NSW RURAL FIRE SERVICE

Your reference: SSD-9874
Our reference: DA20191105000854-Original-1

Development Application

Walla Walla NSW AUS, 1//DP1069452, 17//DP753735, 87//DP753735, 16//DP753735, 21//DP753735, 20//DP753735, 118//DP753735, 108//DP753735, 109//DP753735, 89//DP753735, 88//DP753735

PLANT SUMMARY "WALLA WALLA"			
Total Inverter Power of Plant @50°C:		380 MVA	
Total DC Peak Power (STC):		315.03 MWp	
PV Modules :			
- BF HC 480Wp			
Area:	Fenced area	Fence length	
	546.6 Ha	14,885 m

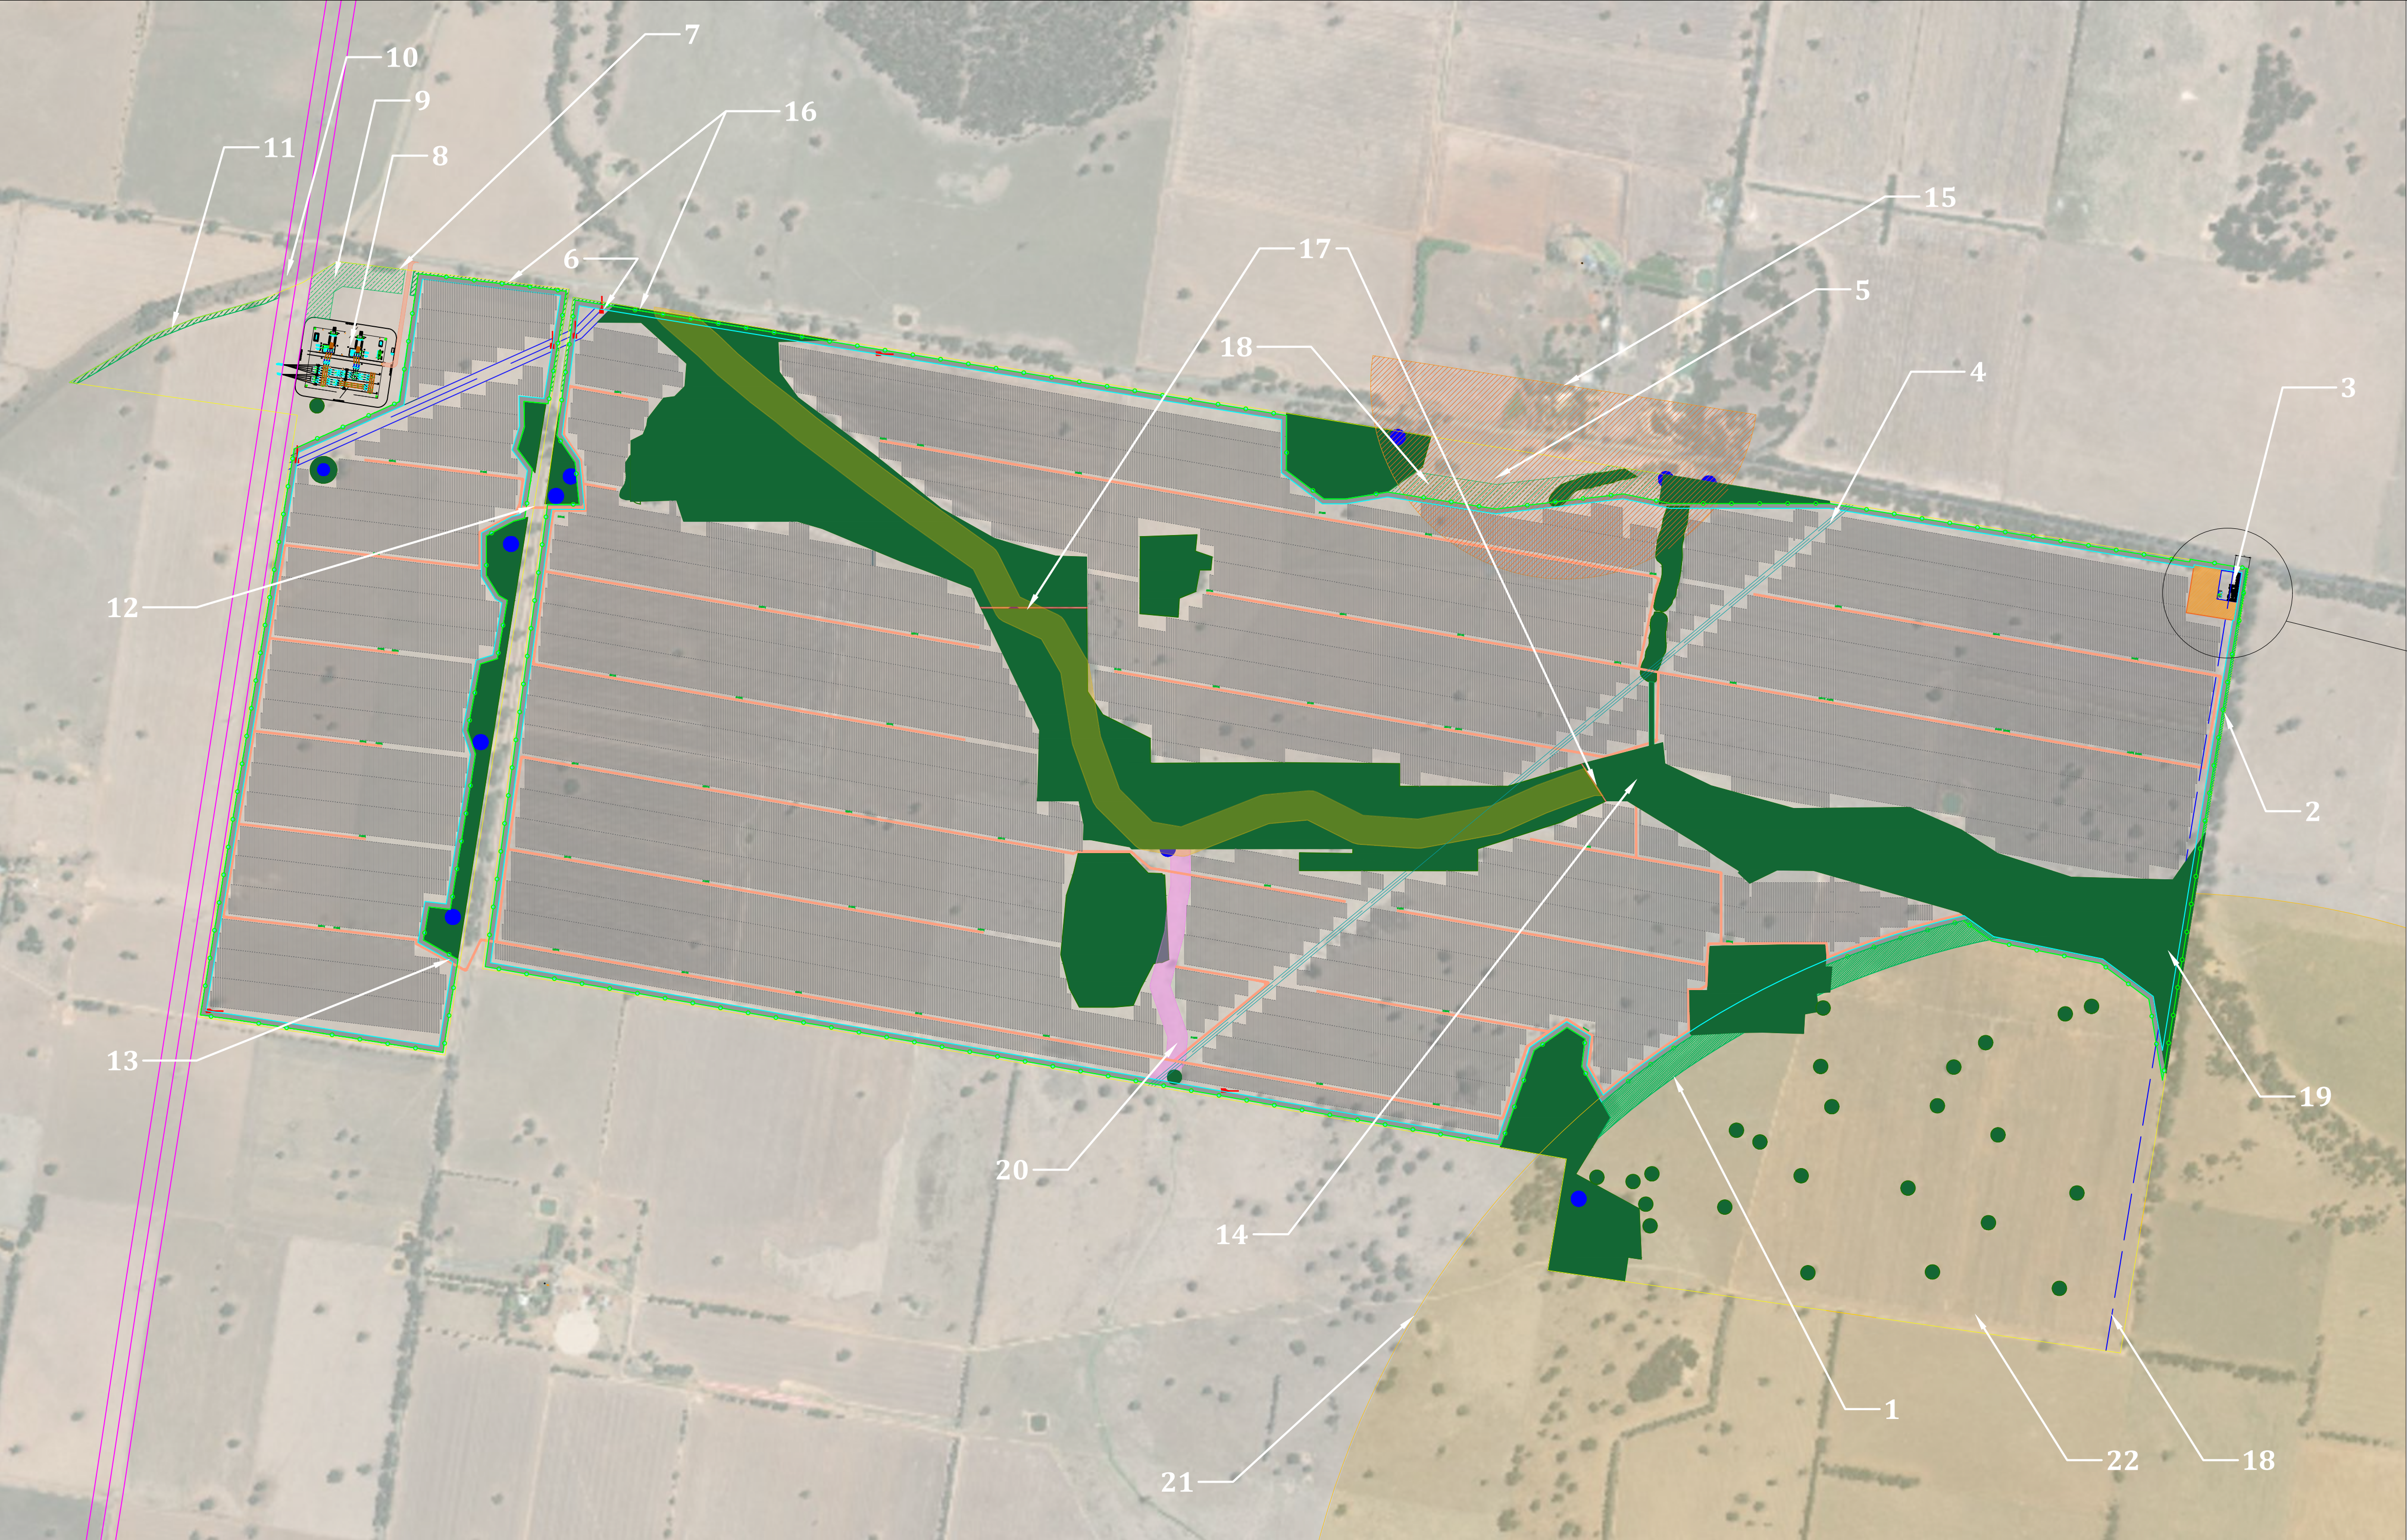
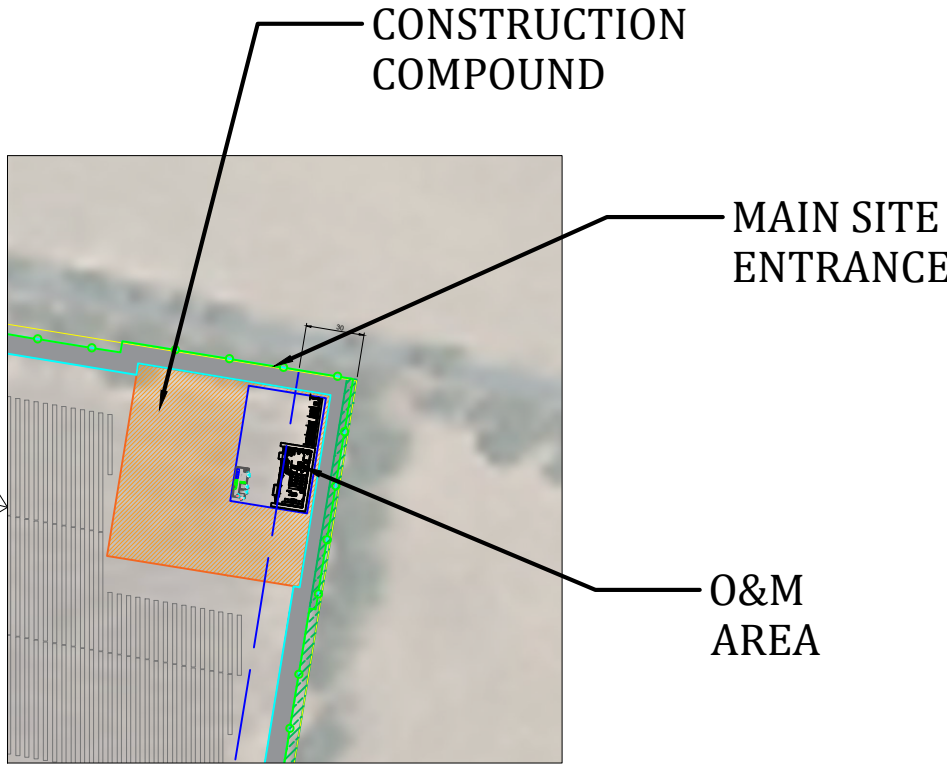
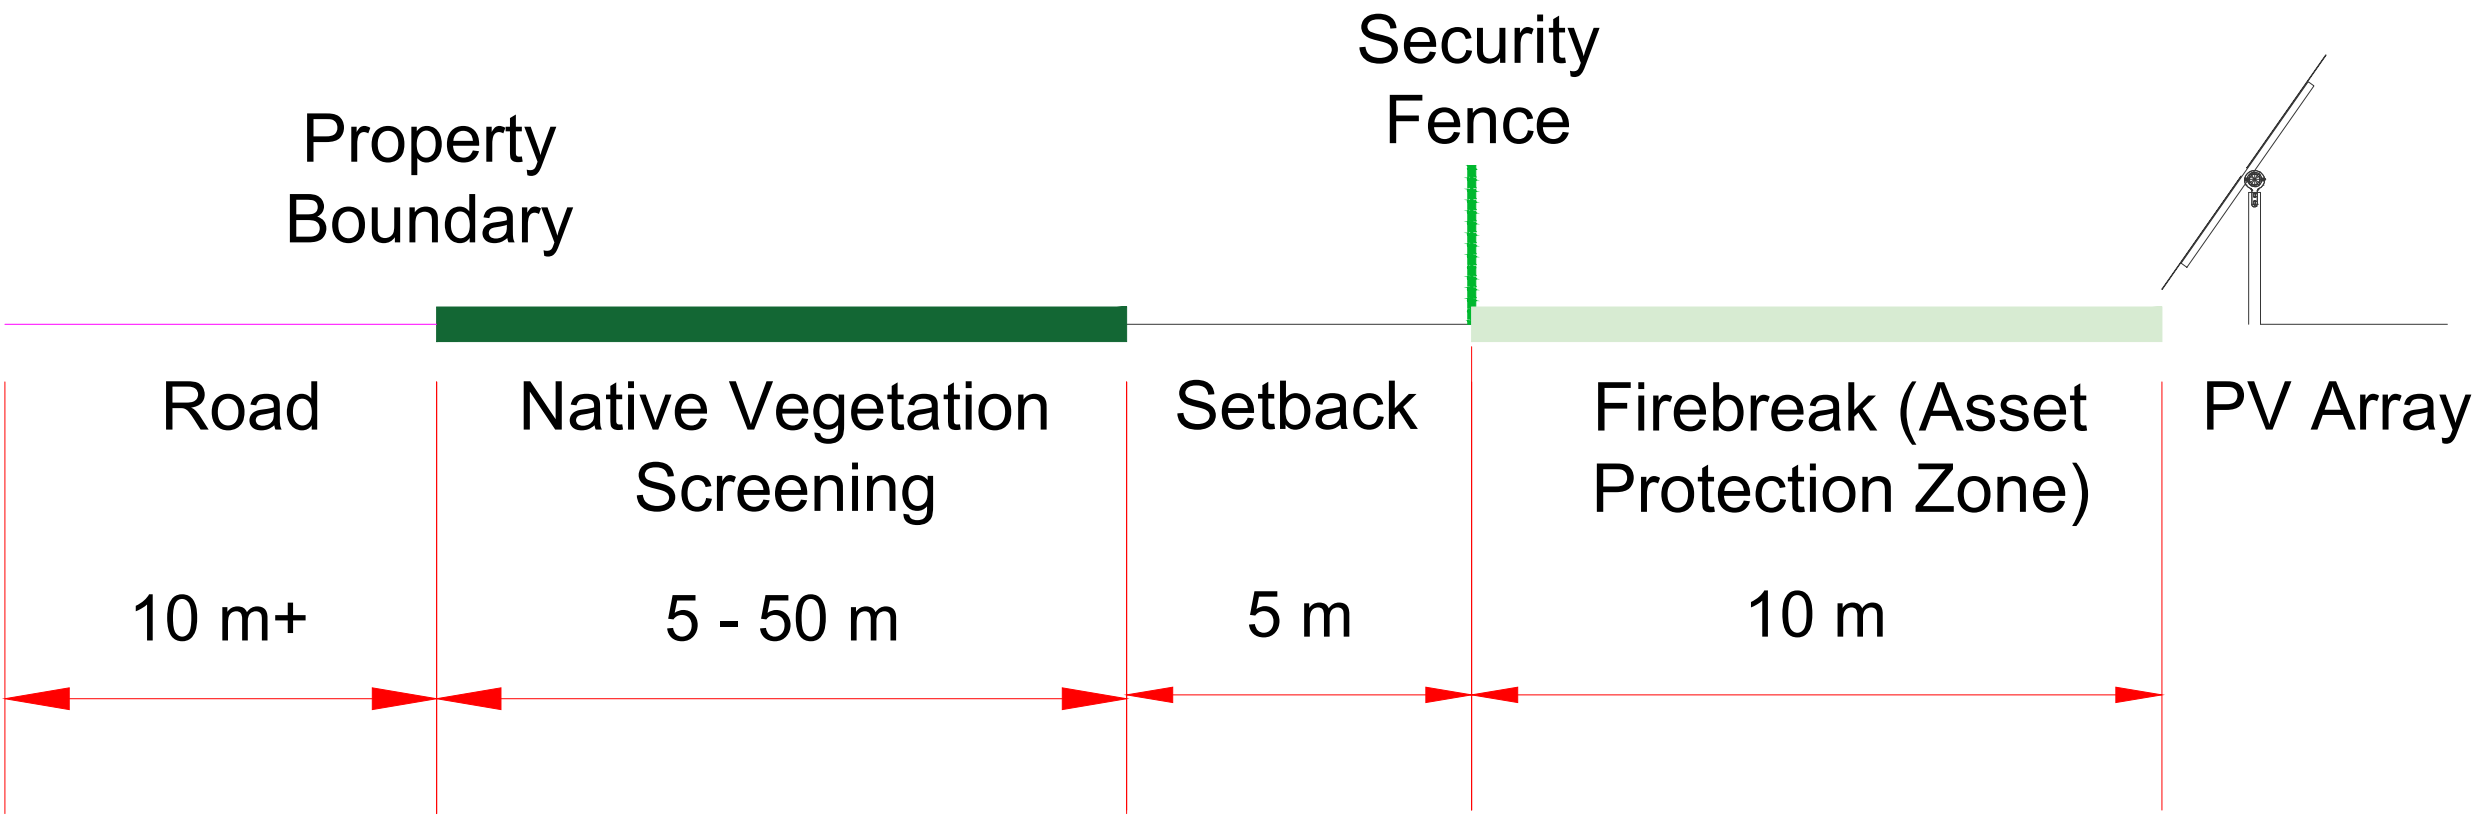
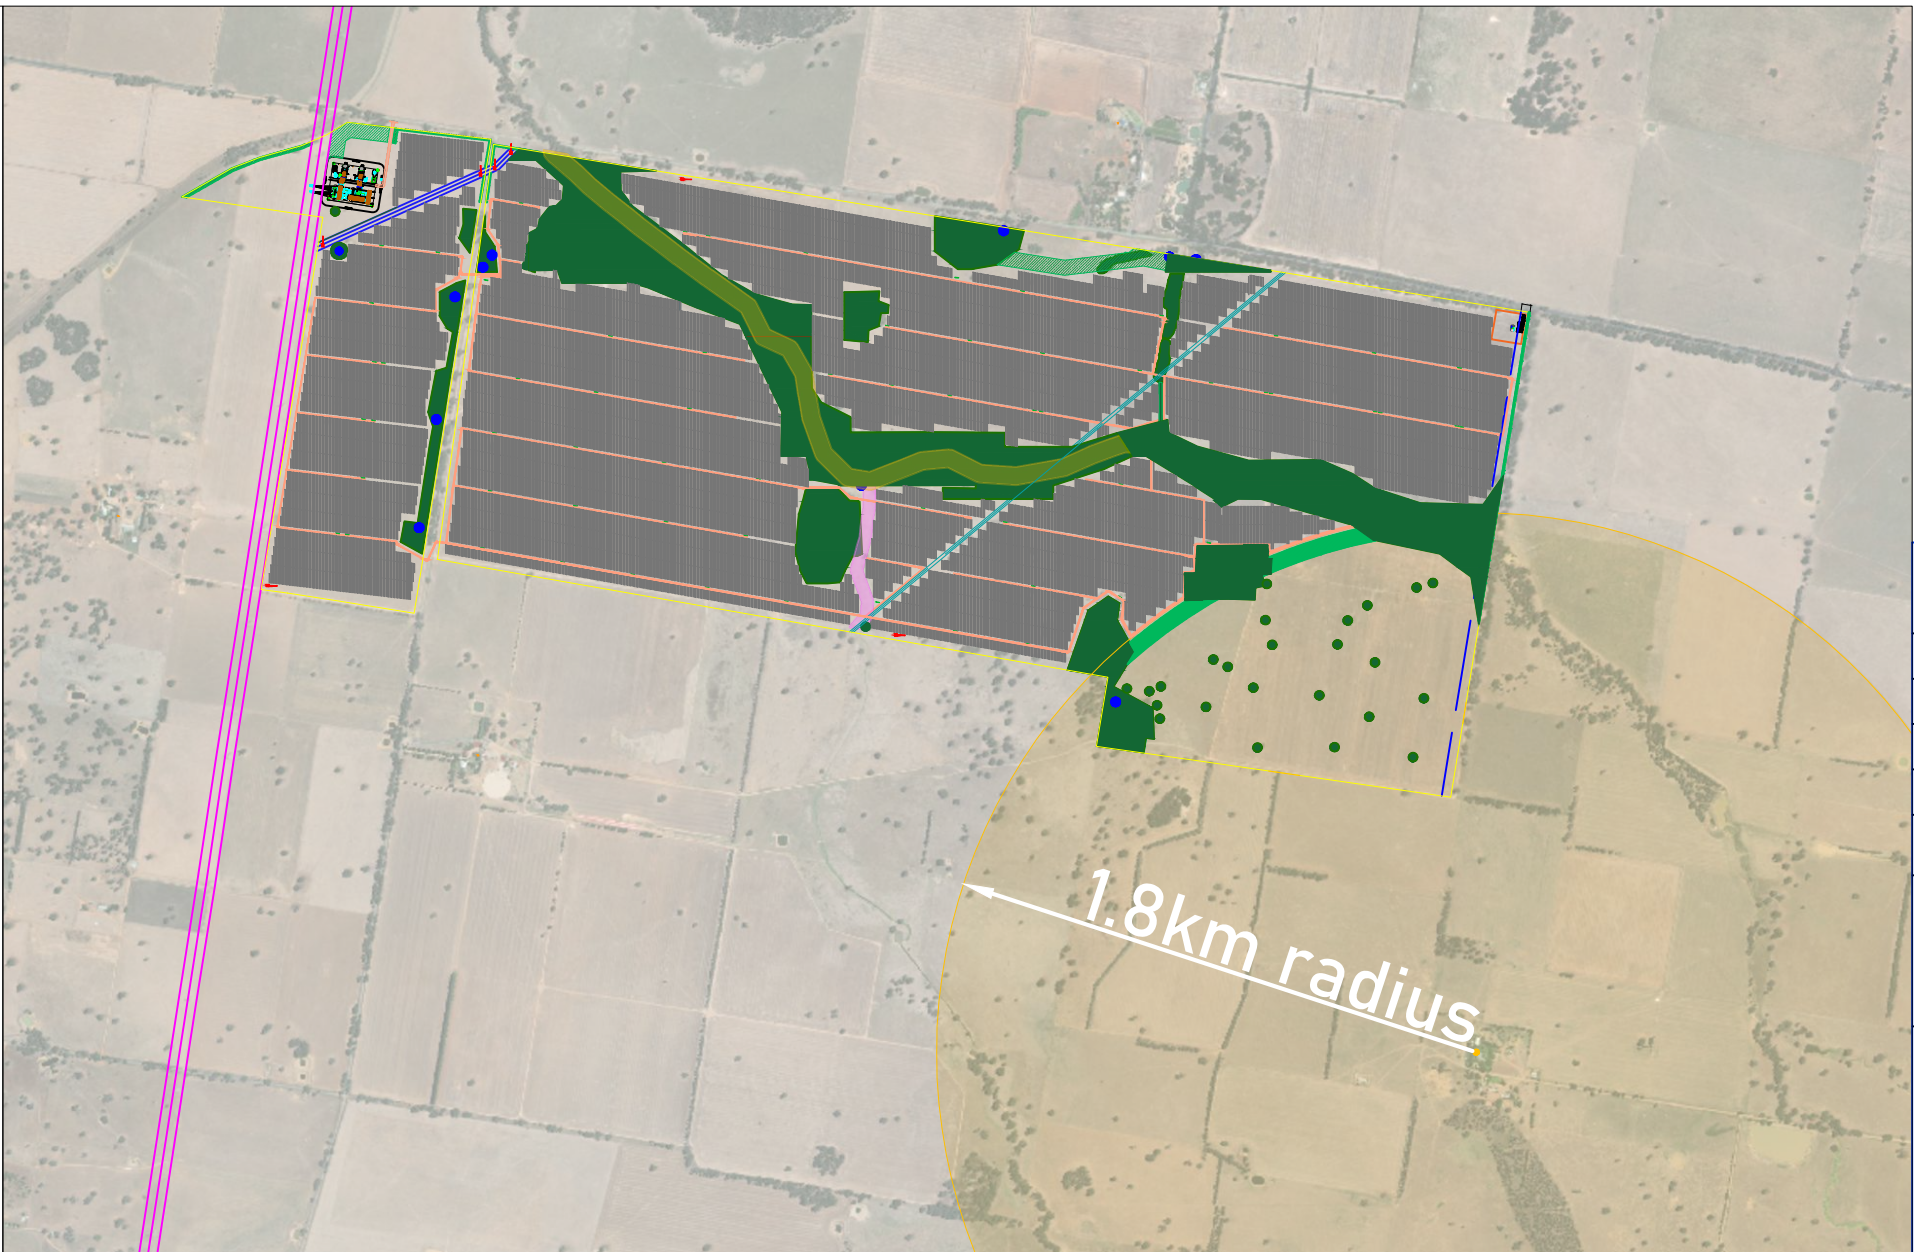
2. The entire solar array development footprint shall be managed as an asset protection zone as outlined within section 4.1.3 of *Planning for Bush Fire Protection 2006* and the NSW RFS document *Standards for asset protection zones*.

3. To allow for emergency service personnel to undertake property protection activities, a 10-metre defendable space, managed as an asset protection zone, shall be provided around the buildings, substation, battery storage units, around the outside perimeter of the solar array, and around all areas of unmanaged vegetation being retained within the site.

4. An access road designed and constructed to comply with the specifications outlined in section 4.1.3(3) of *Planning for Bush Fire Protection 2006* shall be provided along the property boundary/fence line and around all areas of unmanaged vegetation being retained within the site.

6. A minimum 20,000-litre water supply (tank) fitted with a 65mm Storz fitting shall be located adjoining the internal property access road within the required asset protection zone.
